MP 07_0006 - INNER WEST MARINA

**PROPONENT'S RESPONSE
TO SUBMISSIONS FROM AGENCIES AND THE PUBLIC**

3 MARCH 2011

Design H.B.	Scales 1:1000 UNO	Job No. 01013
Drawn S.K.	Date 31.08.09	Dwg. No. DA08
App'd.	Sheet Size B1	Rev. No. 03

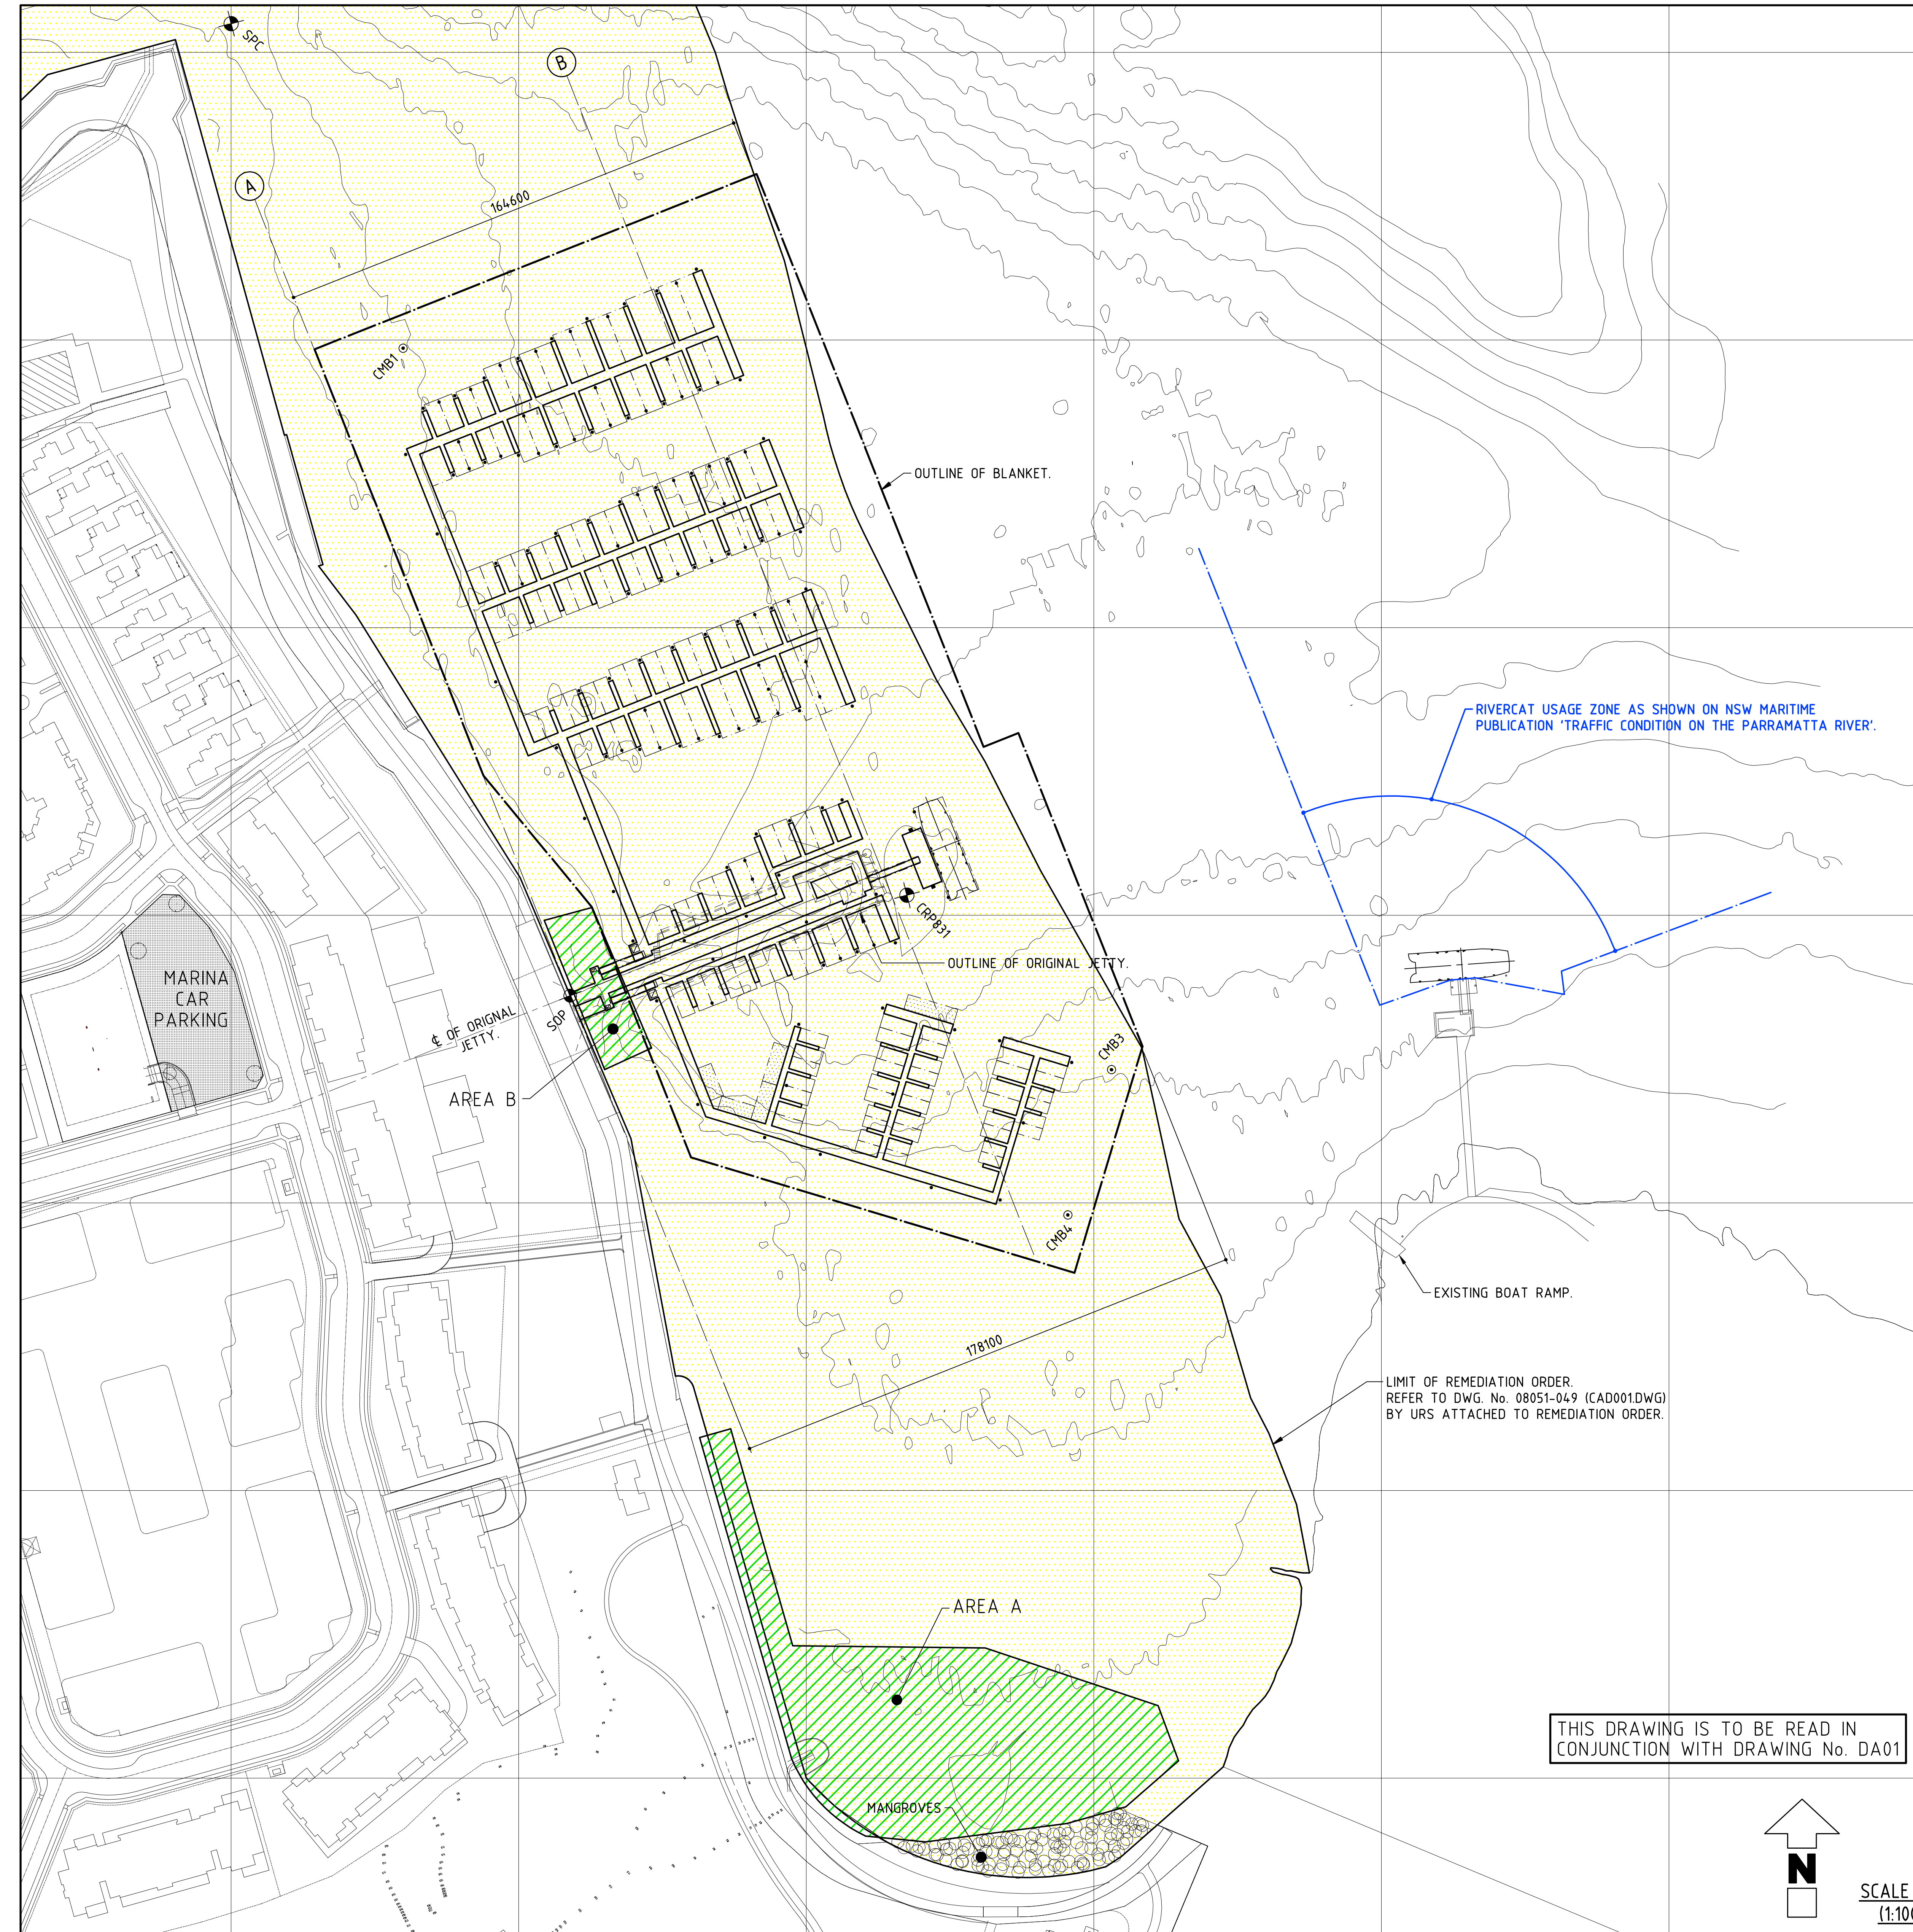
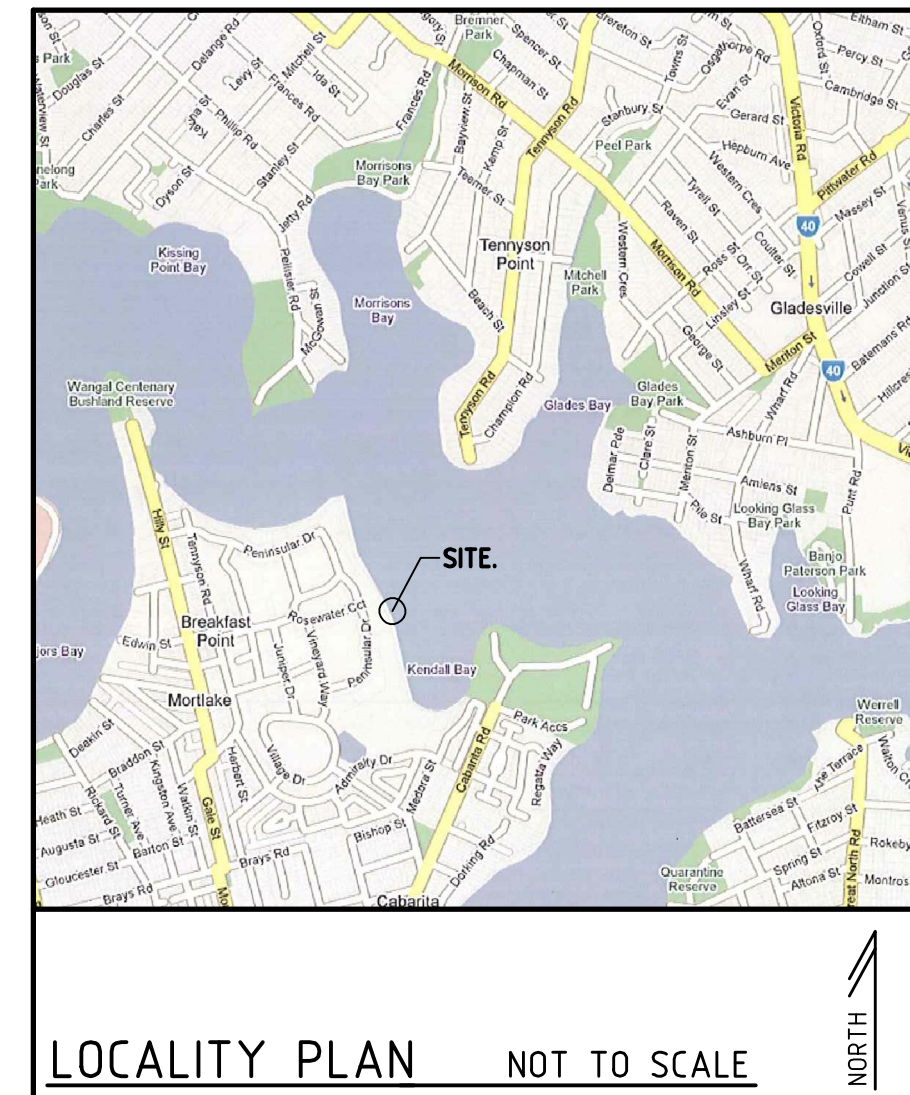
4.2.1 *The proposed number of car parking spaces (58) does not adequately cater for the likely demand of marina berth holders and kiosk patrons.*

The proposal includes 58 car parking spaces for marina patrons and visitors, the marina manager, service and delivery vehicles and kiosk patrons.

- 3.6 *“Based on 0.3 spaces per berth, one employee (the manager) and the kiosk of some 76m², the proposed marina would require some 55 parking spaces.*
- 3.7 *58 spaces are proposed, including one disabled space, as shown in Figure 3. The proposed provision therefore satisfies this requirement, and is considered to be appropriate.*
- 3.8 *We note that a proportion of the berths may be used by residents of the Breakfast Point development. This may reduce the parking demands at the proposed marina as some residents are likely to walk to and from the facility and would therefore not require parking.”*

The proposed car parking rate of 58 spaces satisfies the AS 3962 – 2001 Guidelines for car parking. The Report concludes (page 12):-
